Our Reference: SYD14/00220/03 (A10778569)

Department Ref: SSD 6407

STAGED COMMERCIAL PRECINCT
185-195 FIFTEENTH AVENUE, WEST HOXTON

FIGURE 5 - PROPOSED ROUNDABOUT

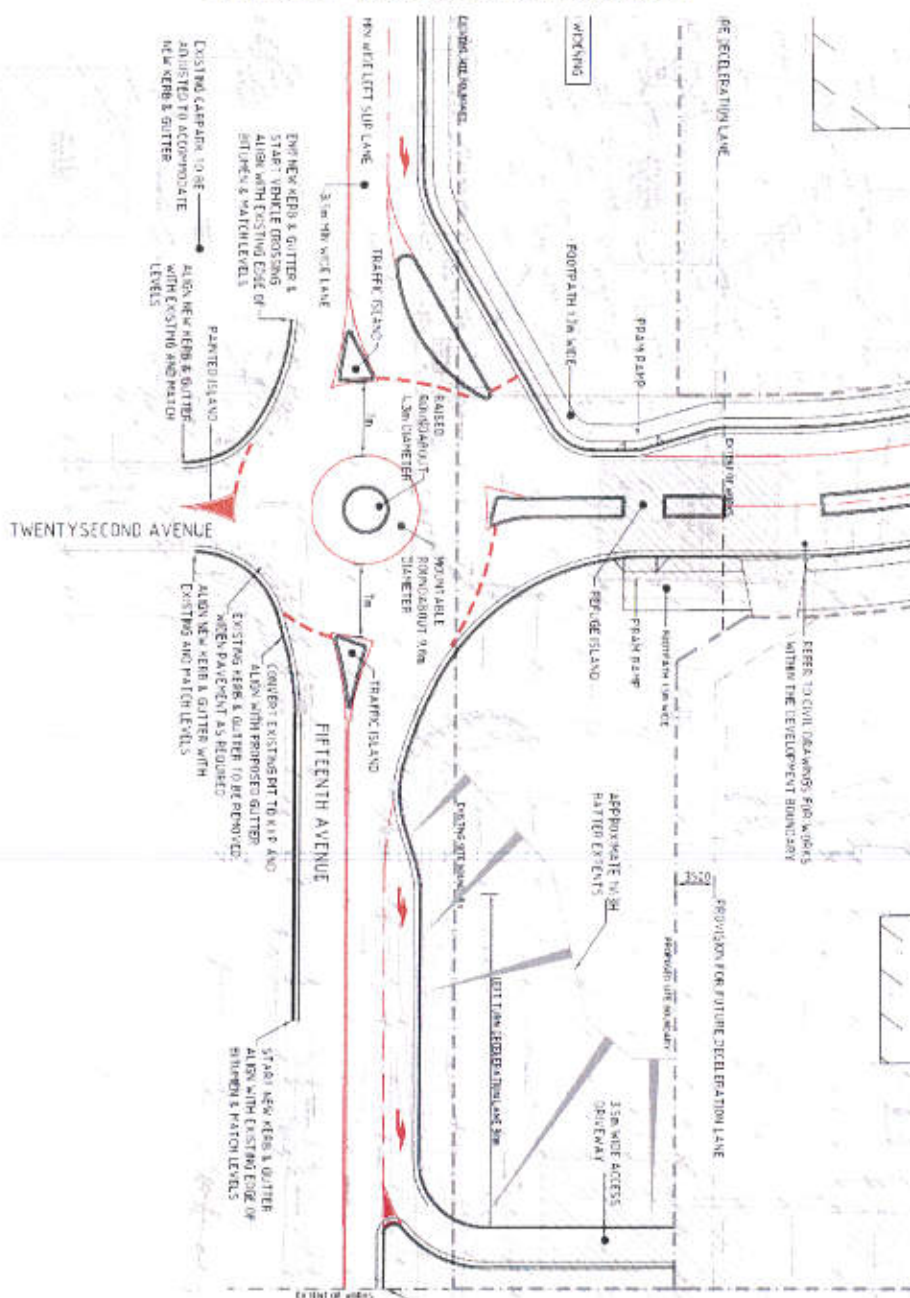
1. Access to the site from Fifteenth Avenue should be limited to that at the proposed roundabout, and the deceleration and acceleration lanes removed.
2. The planned bus stop provision will be required and designed to the appropriate standard. However, this will be removed at a later date once the road is upgraded.
3. The proponent should be advised that the planned roundabout is likely to be replaced by traffic signals when the road is upgraded.
